# IS-FBC: Building Design Standards (BDS)

Complies	More Info	Does Not Comply	N/A	Comments
<b>BUILDING DESIGN STANDARDS (BDS)</b>					Review (2/17/16) Caitlin Cameron, Rick Knowland, Jean Fraser
<b>1. Neighborhood Context</b>					
Intent	<input checked="" type="checkbox"/>	<input type="checkbox"/>	<input type="checkbox"/>	<input type="checkbox"/>	
Guidelines	<input type="checkbox"/>	<input checked="" type="checkbox"/>	<input type="checkbox"/>	<input type="checkbox"/>	The material palette appears dark compared to the context – samples? The review panel was concerned about the building in context of Hampshire Street, attention should be given to those parts of the building visible from the street.
<b>2. Massing &amp; Proportion</b>					
Intent	<input type="checkbox"/>	<input type="checkbox"/>	<input checked="" type="checkbox"/>	<input type="checkbox"/>	The panel is concerned about the scale of the garage façade on Franklin – the proportion of the garage to the overall building is quite tall and very little makes the two-story wall comfortable at pedestrian scale.

**BUILDING ELEVATIONS**

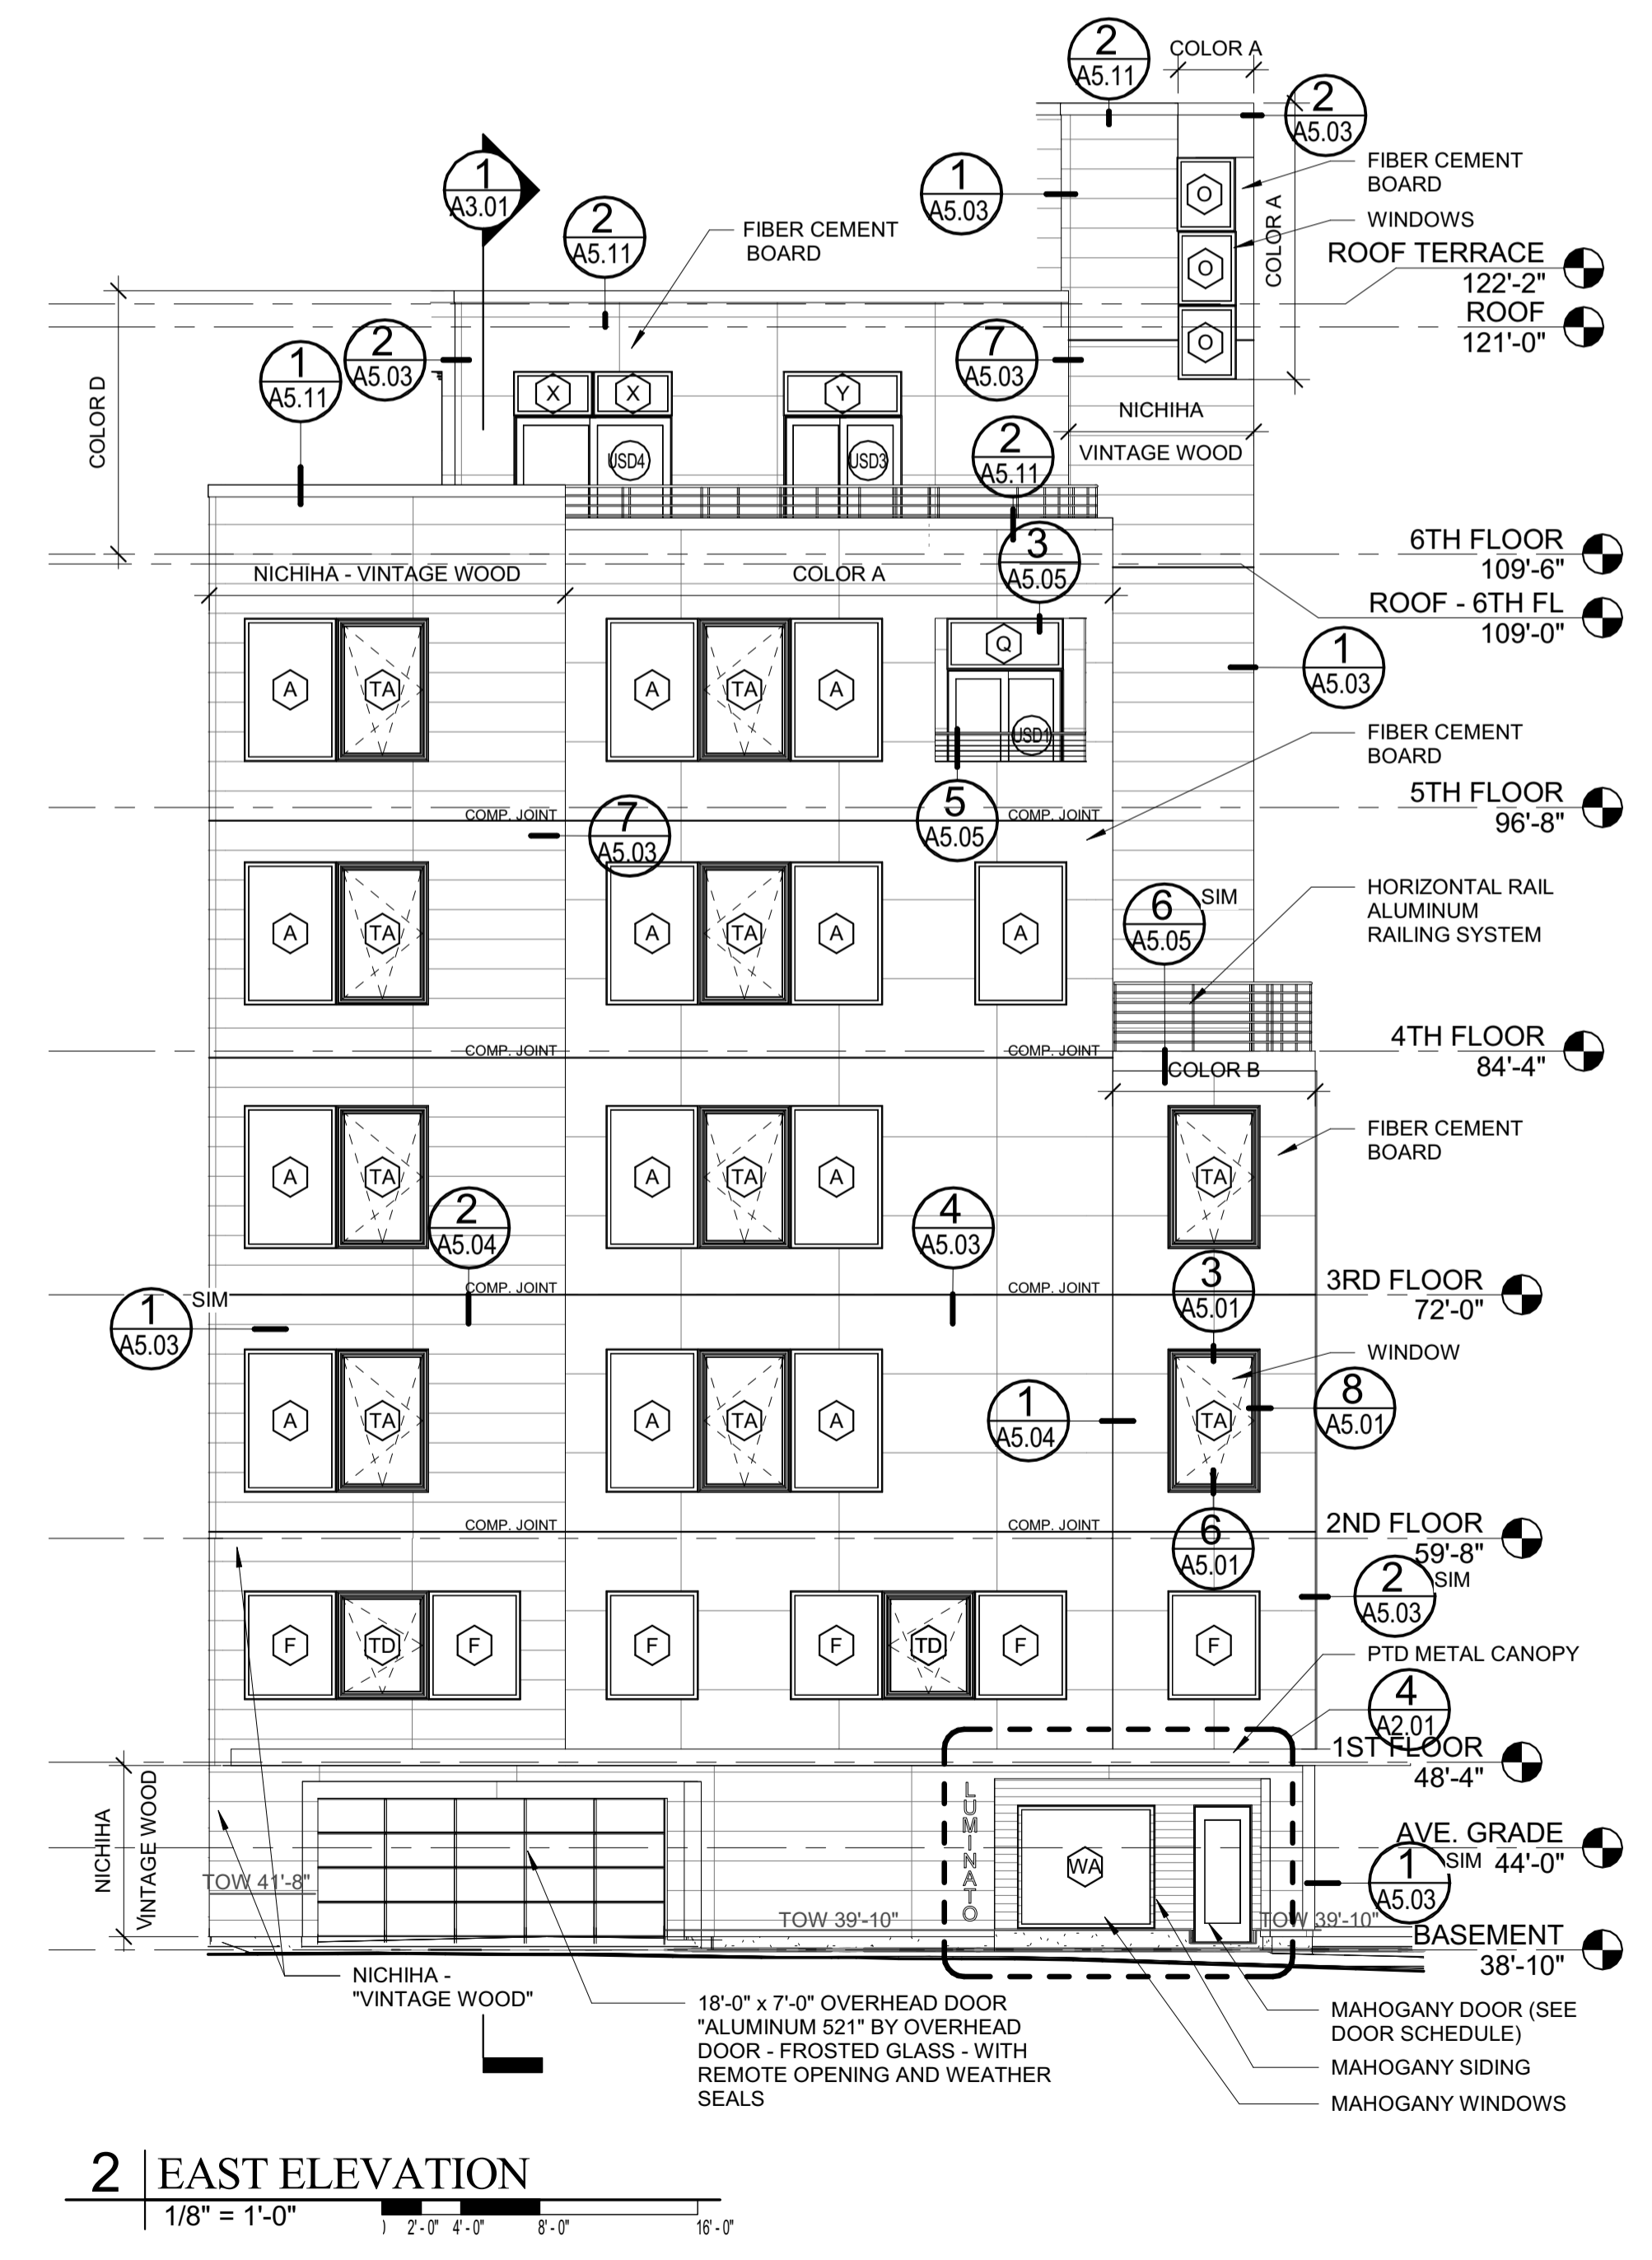
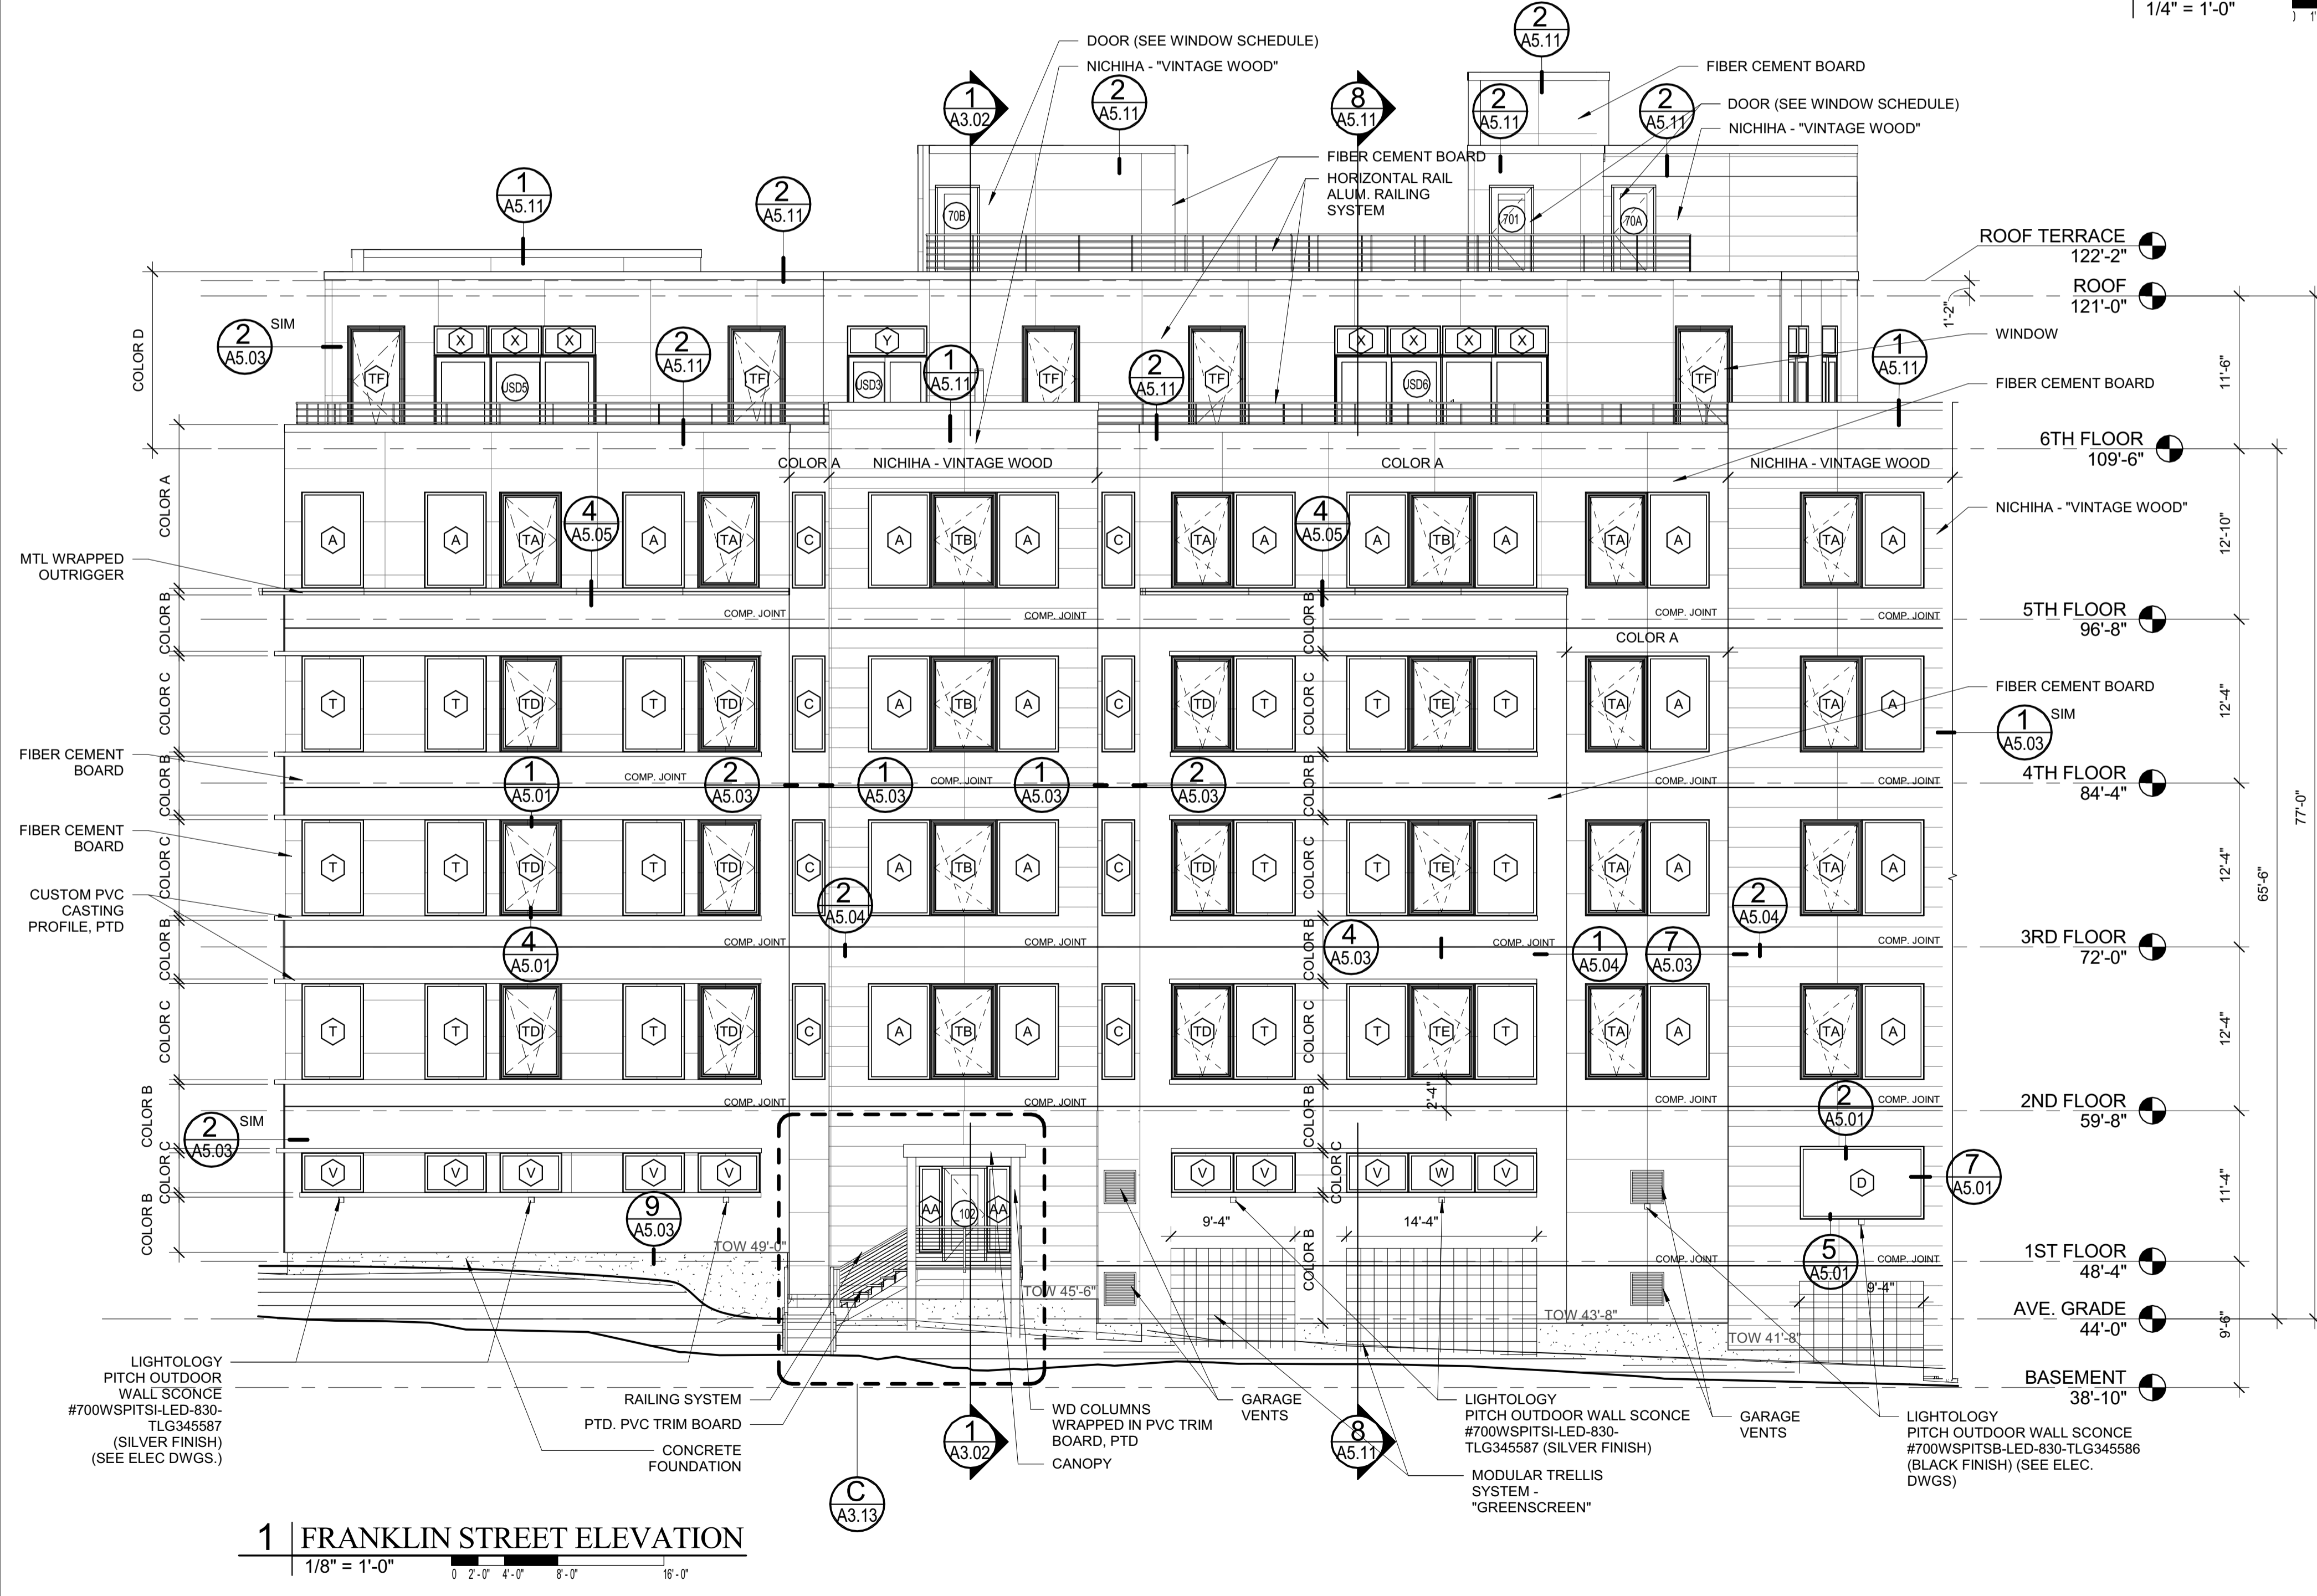
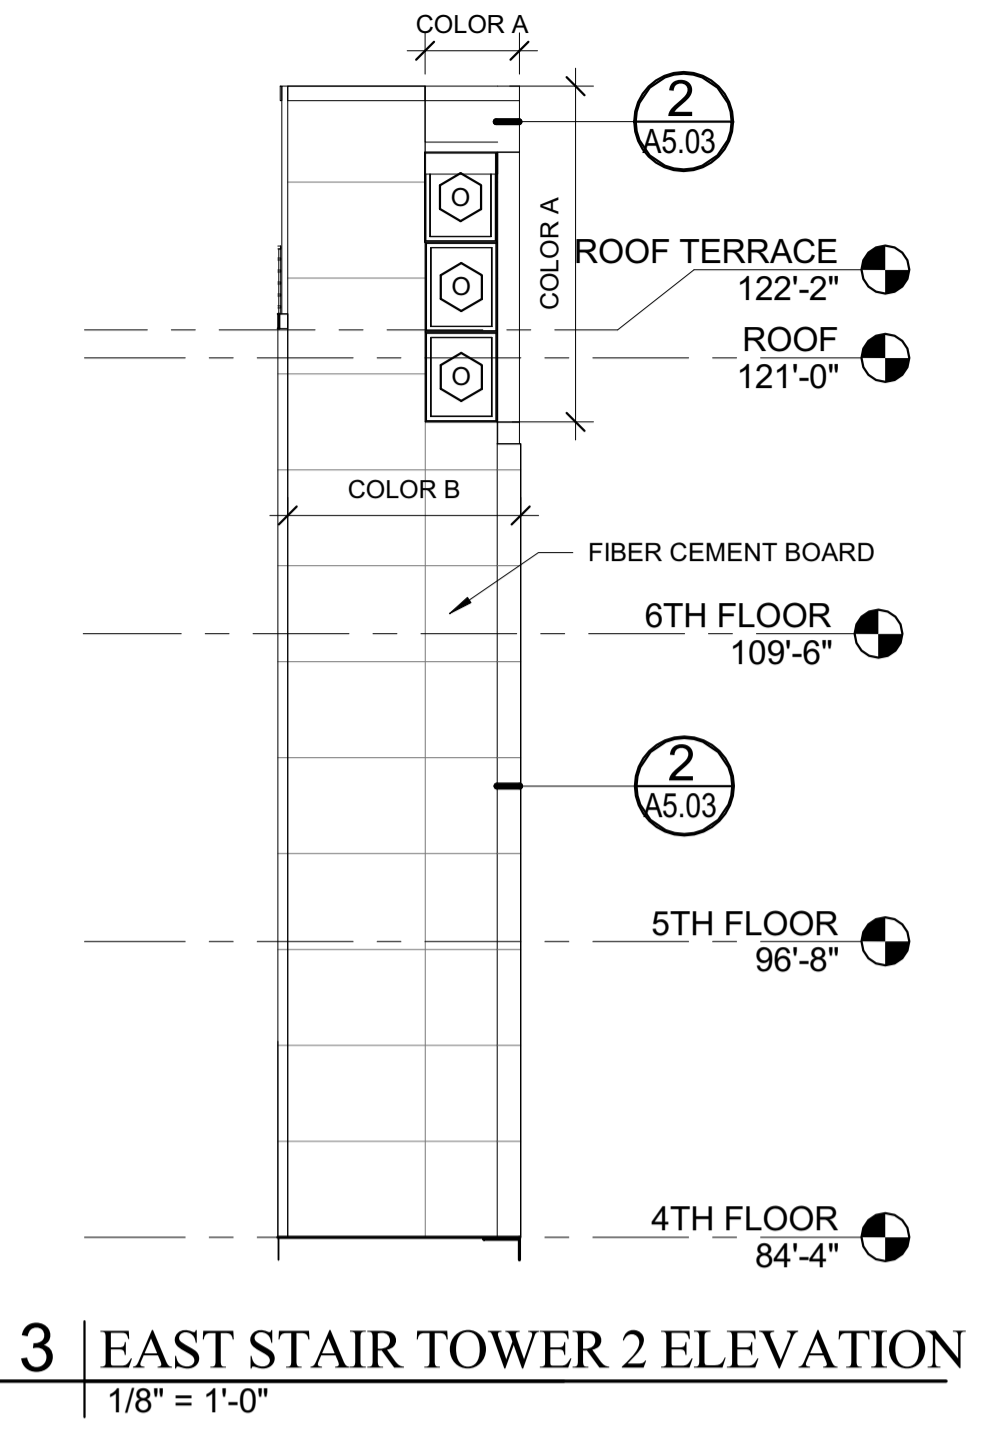
Guidelines	<input type="checkbox"/>	<input type="checkbox"/>	<input checked="" type="checkbox"/>	<input type="checkbox"/>	Bring more emphasis to the corner: see sketch attached for notes. The stepbacks help to mitigate the scale of the new, large building compared with the smaller context. Stepback at back corner would alleviate the scale and height impacts for the 2 and 3-story buildings.
Standard 2.1	<input type="checkbox"/>	<input type="checkbox"/>	<input type="checkbox"/>	<input checked="" type="checkbox"/>	
<b>3. Articulation &amp; Composition</b>					
Intent	<input type="checkbox"/>	<input type="checkbox"/>	<input checked="" type="checkbox"/>	<input type="checkbox"/>	The Franklin garage façade does not, yet, meet the articulation standards.
Guidelines	<input type="checkbox"/>	<input type="checkbox"/>	<input checked="" type="checkbox"/>	<input type="checkbox"/>	
Standard 3.1: 3 required	<input type="checkbox"/>	<input type="checkbox"/>	<input checked="" type="checkbox"/>	<input type="checkbox"/>	This standard is not met for the garage façade: see comments in Section 8

Standard 3.2	<input checked="" type="checkbox"/>	<input type="checkbox"/>	<input type="checkbox"/>	<input type="checkbox"/>	
Standard 3.3: Blank Wall	<input type="checkbox"/>	<input type="checkbox"/>	<input checked="" type="checkbox"/>	<input type="checkbox"/>	Franklin garage façade – more articulation is requested to break up the blank wall.

Standard 8.1	<input type="checkbox"/>	<input type="checkbox"/>	<input checked="" type="checkbox"/>	<input type="checkbox"/>	The review panel feels this standard is not yet met – there is a lack of articulation and visual interest on a long and prominent façade. Suggestions: carry the plane changes all the way down the façade; bring the cladding material further down the façade; incorporate openings or windows into the upper parking deck; chose a base material color that better relates to the upper floors; incorporate lighting; incorporate landscaping. The panel was especially concerned with CPTED when it comes to visibility and safety along this façade. Refer to the sketch for further notes and clarification.
Standard 8.2	<input checked="" type="checkbox"/>	<input type="checkbox"/>	<input type="checkbox"/>	<input type="checkbox"/>	
Standard 8.3	<input checked="" type="checkbox"/>	<input type="checkbox"/>	<input type="checkbox"/>	<input type="checkbox"/>
